CITY OF MERCER ISLAND

October 23, 2020

RE: SUB20-002 (Cheshire Short Plat) Request for Information 1, 7615 E Mercer Way

PRELIMINARY SHORT PLAT
CHESHIRE SHORT PLAT

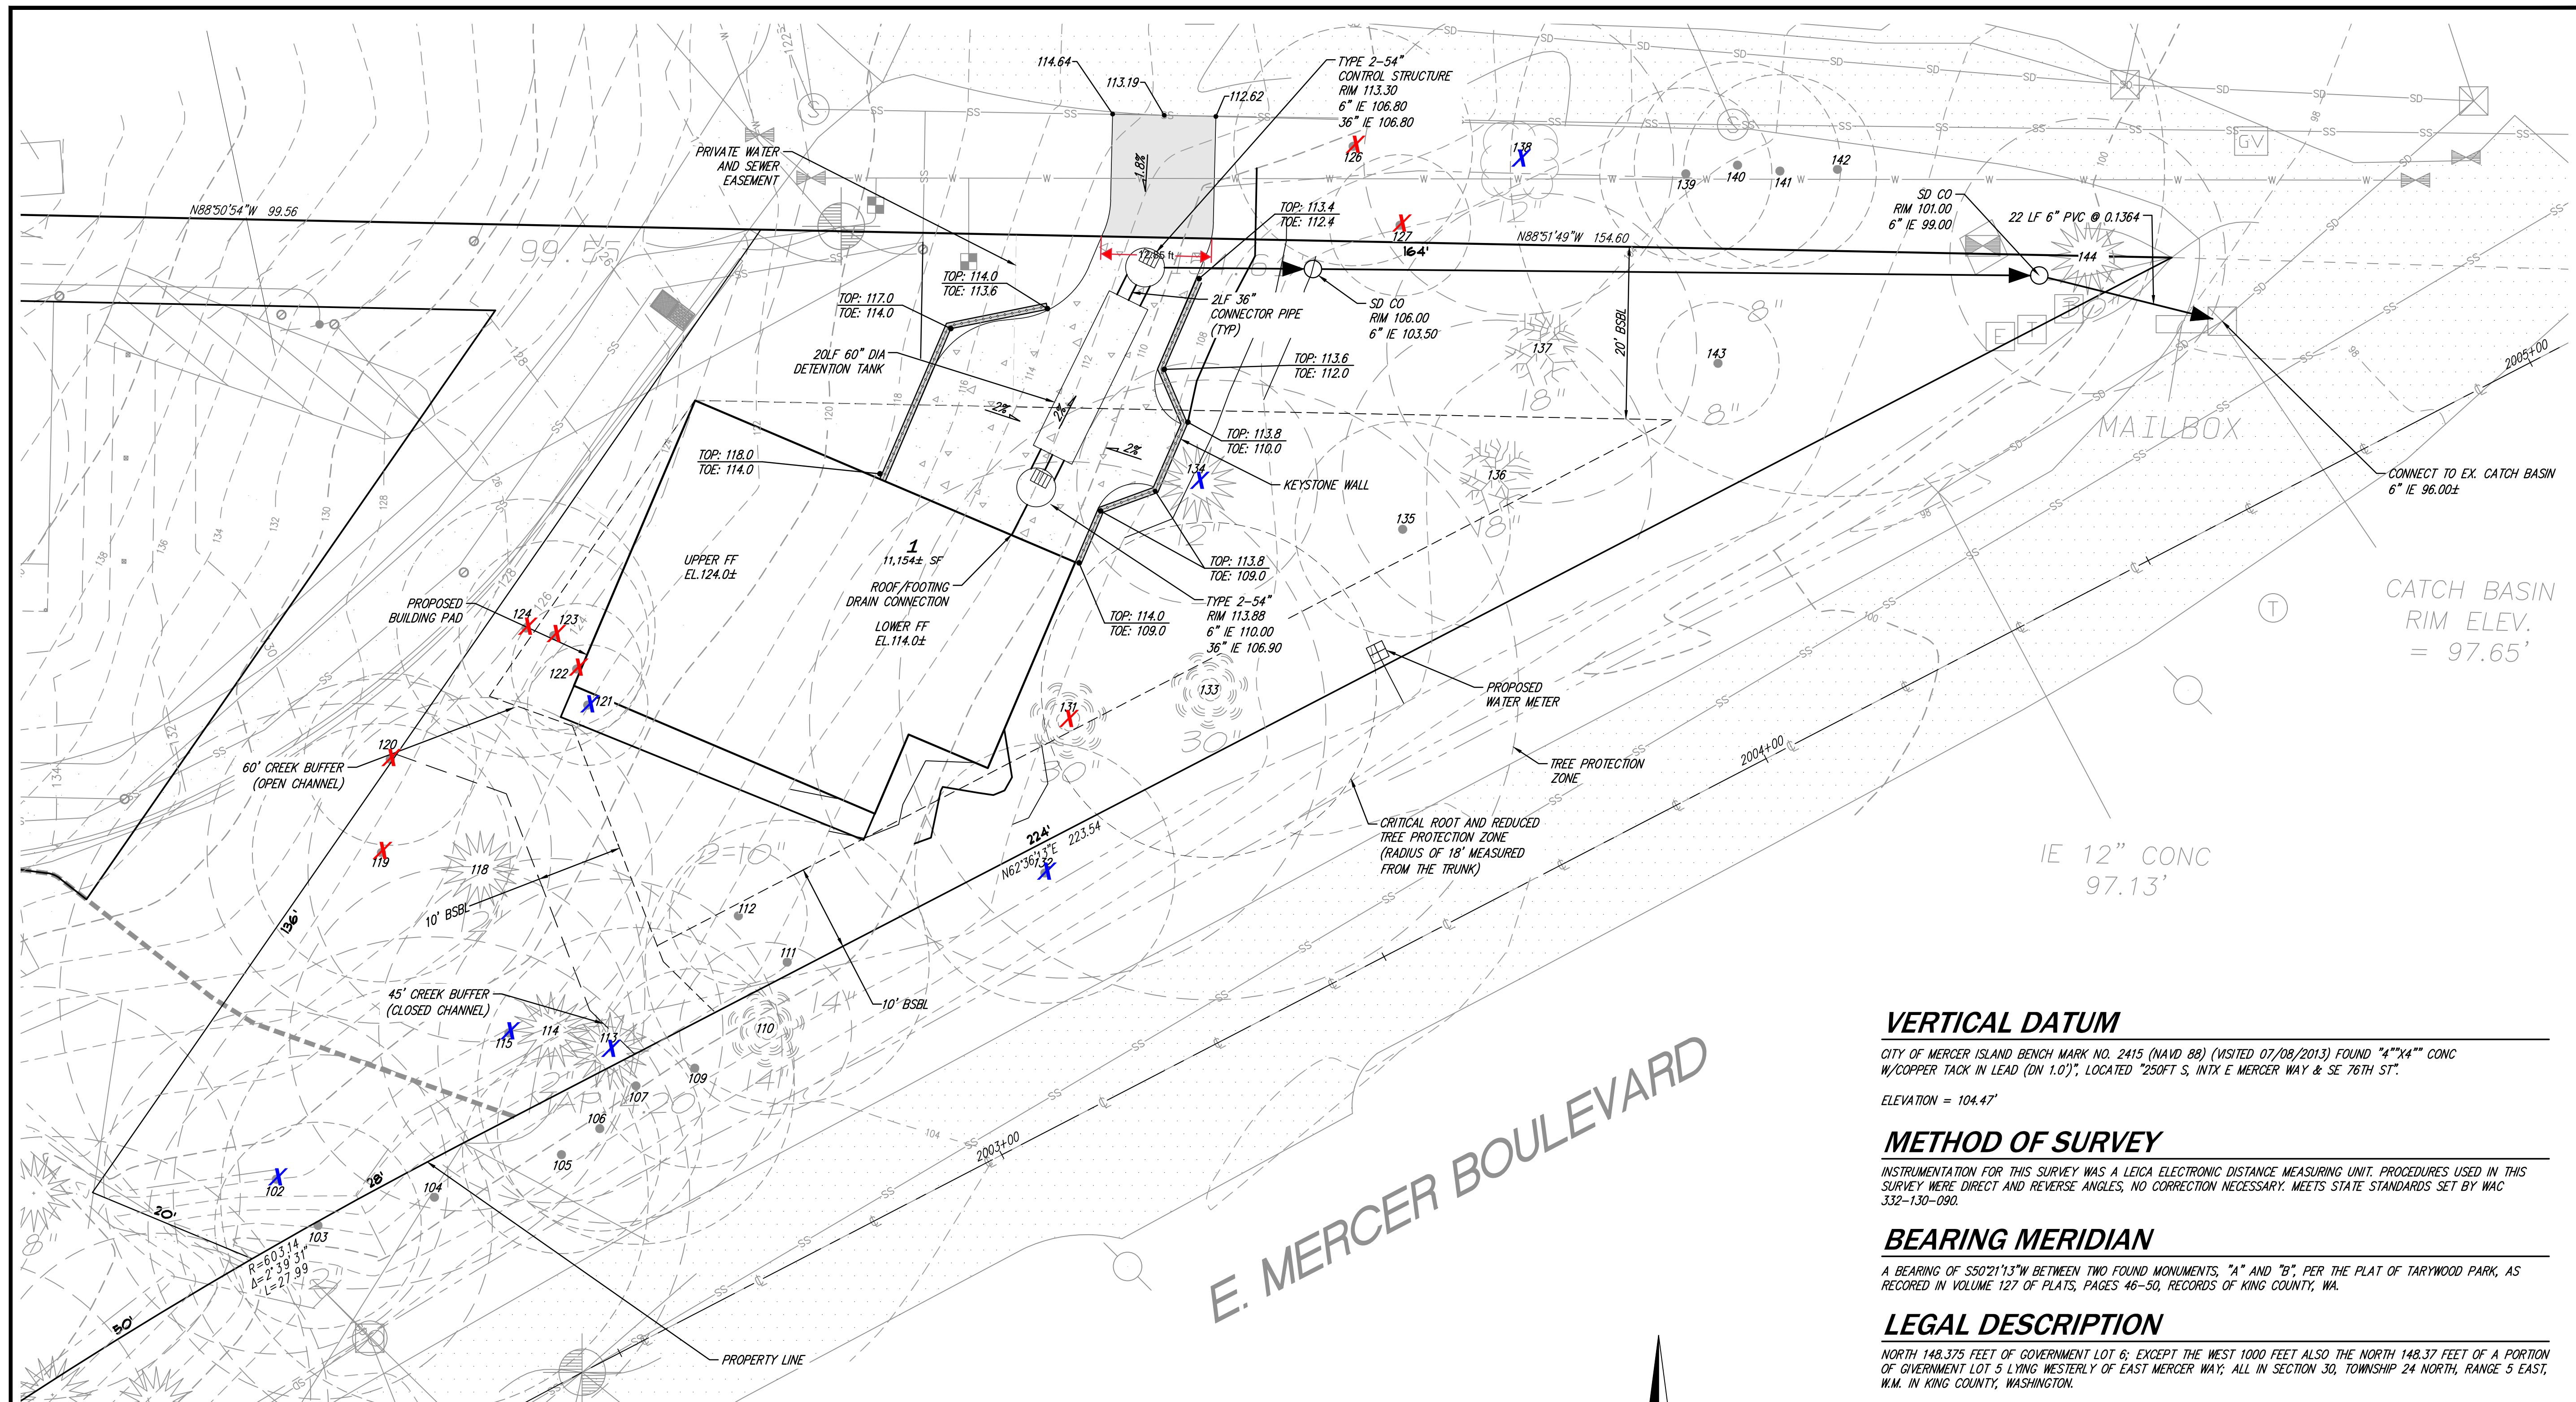
2. The 223.54-foot dimension for the side lot line for the proposed Lot 1, adjacent to E Mercer Way, appears to be incorrect according to the scale provided. As measured using the plan scale, it is closer to 251 feet. Please verify the length of this lot line and update the dimension where shown within the plan set.

1. Please clearly show and call out all new and proposed private easements on the plat drawings.
Core Design Response: A private sewer and water easement has been added to the plat drawings.

Applicant Response: The lot dimension has been revised. An additional segment of 28' as been added to Sheet 2.

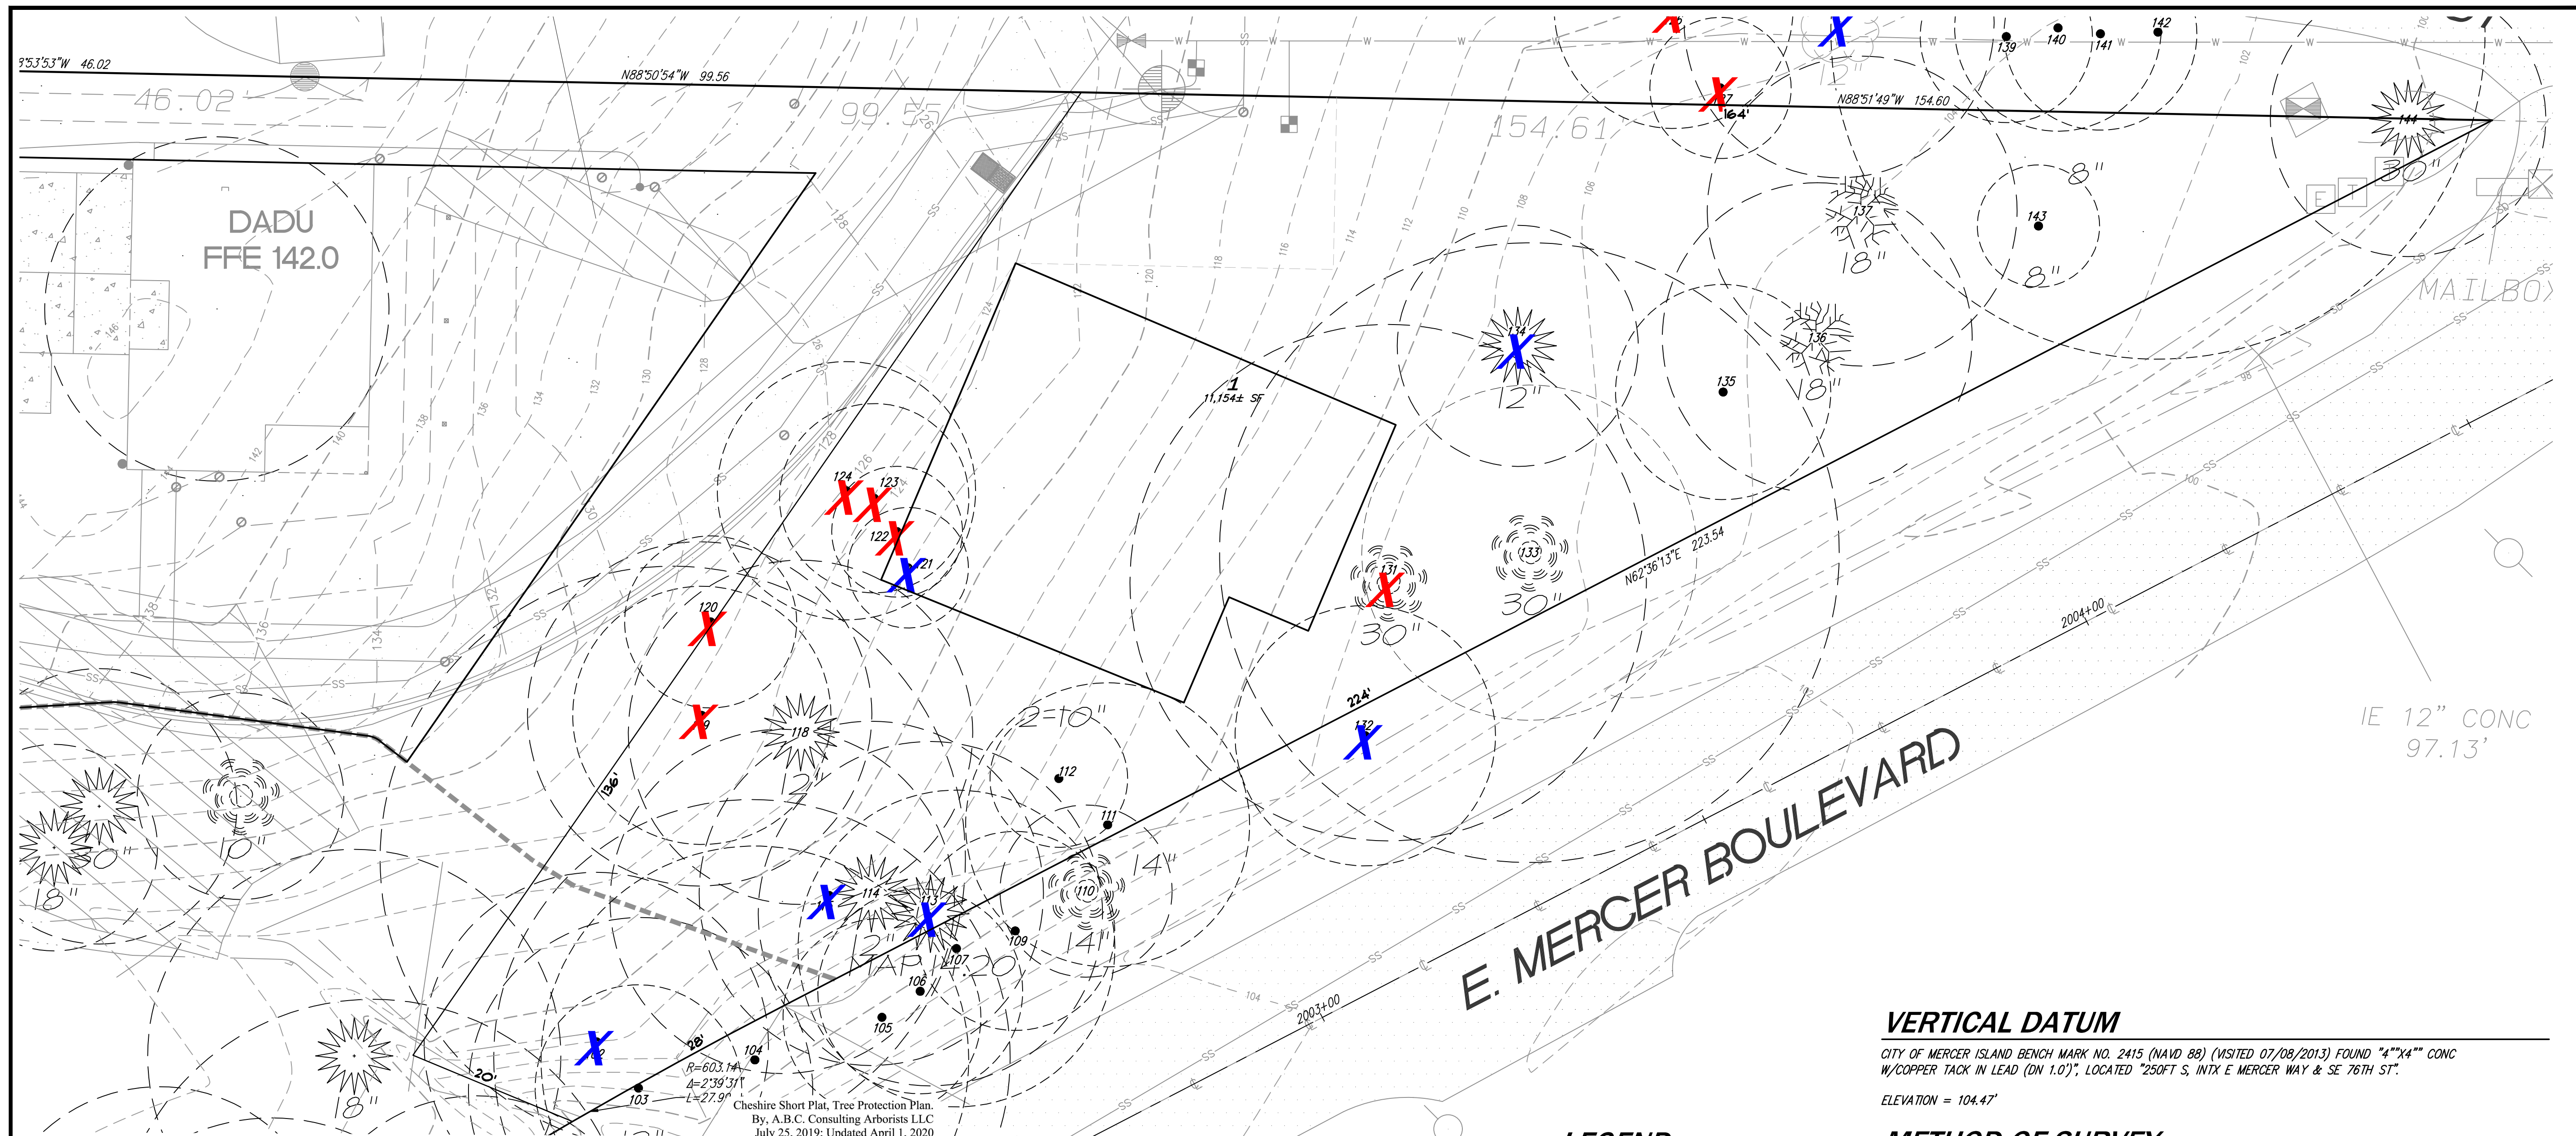
3. Show the building pad for Lot 1 and retained numbered trees with their driplines/approved tree protection zones on the same plan. Call out and show the distance from tree trunk/face not the center of the tree. It appears the proposed building pad encroaches into tree protection zones, and it appears grading is shown within the tree protection area. Note that the sheet showing numbered retained trees will be recorded as part of the plat.

4. The project arborist states the Tree Protection Zone (TPZ) of 36' cannot be changed or reduced to the CRZ without approval. Please provide advanced assessment of the root zone area with a non-invasive technique such as air excavation under arborist supervision and control. The project arborist should review and cite the newest plans including Sheet 3 - Road, Grading & Storm Drainage Plan. The City arborist should be notified when the project arborist will be on-site and be provided with a follow-up memo. This will help determine the extent and position of the building pad. No over excavation or other disturbance will be allowed into the final TPZ.

Core Design Response: The building pad for lot 1 is shown and the distance from the trunk has been called out. There is no proposed grading within the CRZ/TPZ. Daniel Maple of ABC Arborists has discussed this comment with John Kenney. The revised Arborist Report addresses this comment.

Core Design Response: There is a note on the bottom of the tree table that indicate the TPZ for tree 133 can be reduced to 18':

I Made a field examination of Tree 133. It is viable to set the TPZ at 18-feet. Arborist Shall oversee Excavation and Prune Roots as needed. An Application of Cambistat 3-months Prior to construction and 4-inches of Mulch in the CRZ would be beneficial.

DATE	JULY 2020 (1ST SUB)
DESIGNED	SHERI MURATA, P.E.
DRAWN	STEVE E. SIMMONS
APPROVED	SHERI MURATA, P.E.
	ROBERT WEST, PLS
	PROJECT MANAGER
SHEET	OF
2	4
PROJECT NUMBER	19205

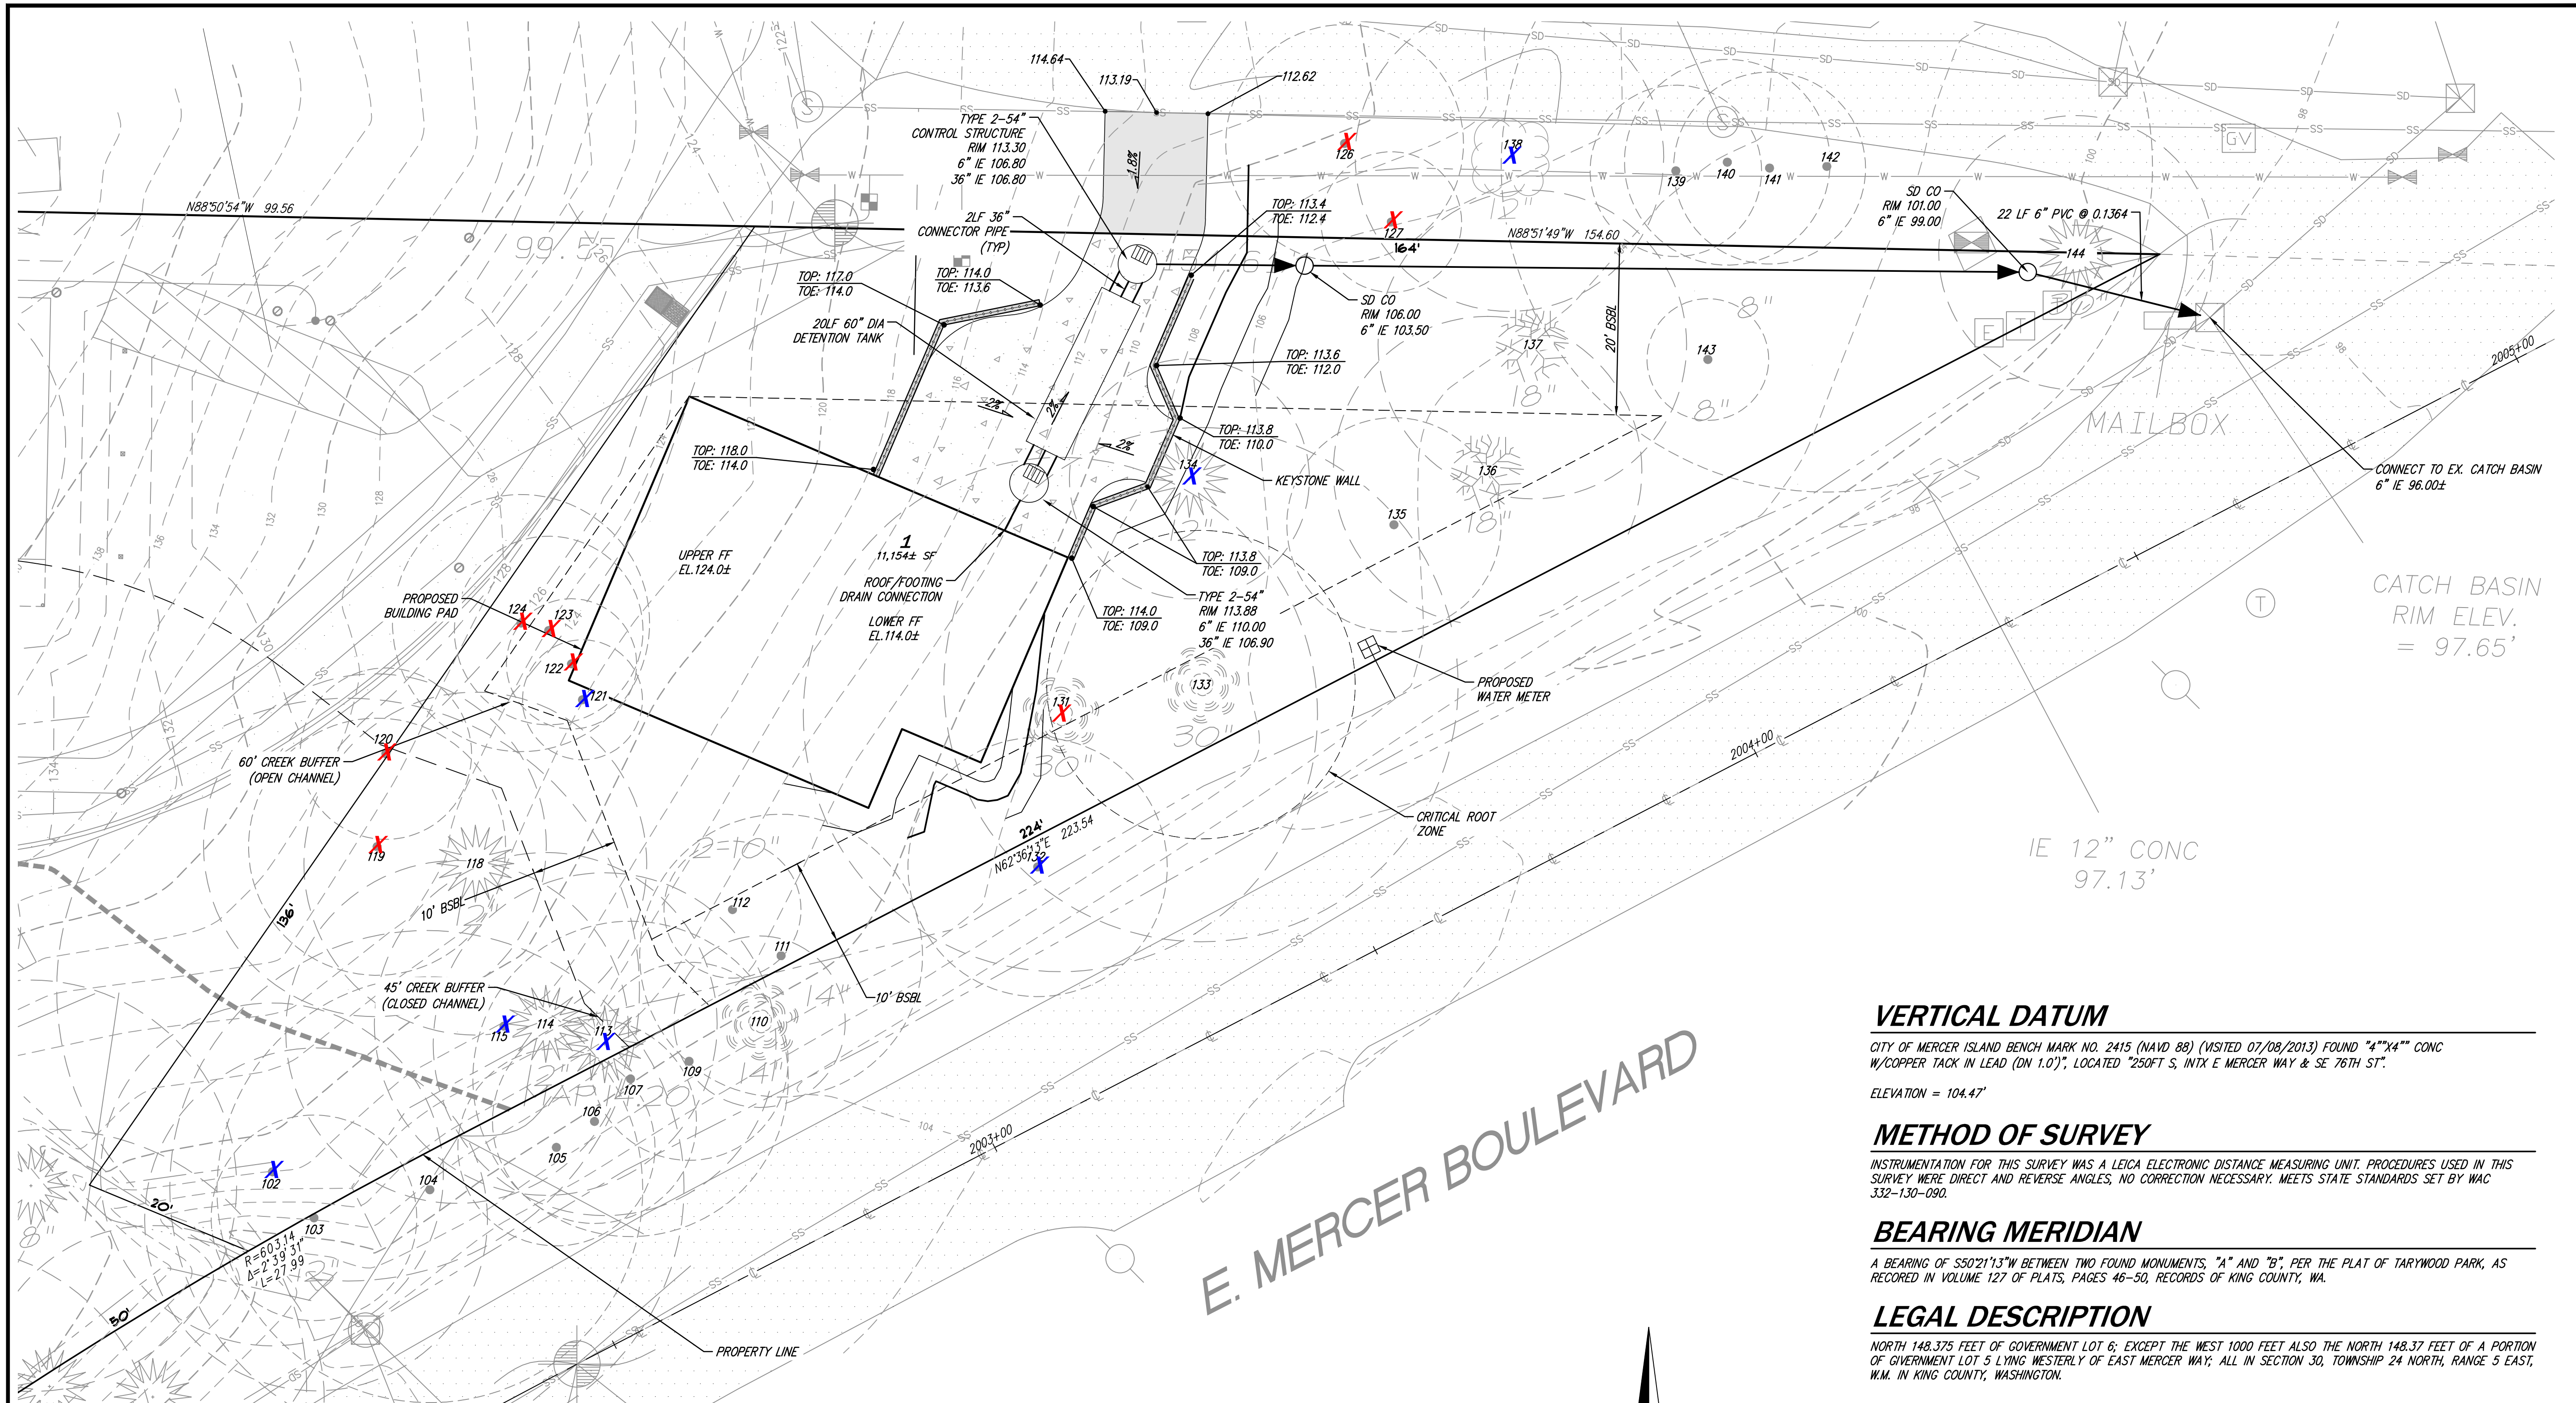
1. Please identify a building pad for Lot 2, consistent with the provisions of MICC 19.09.090.

Applicant Response: A building pad for the existing house and DADU is shown on the preliminary plat sheet.
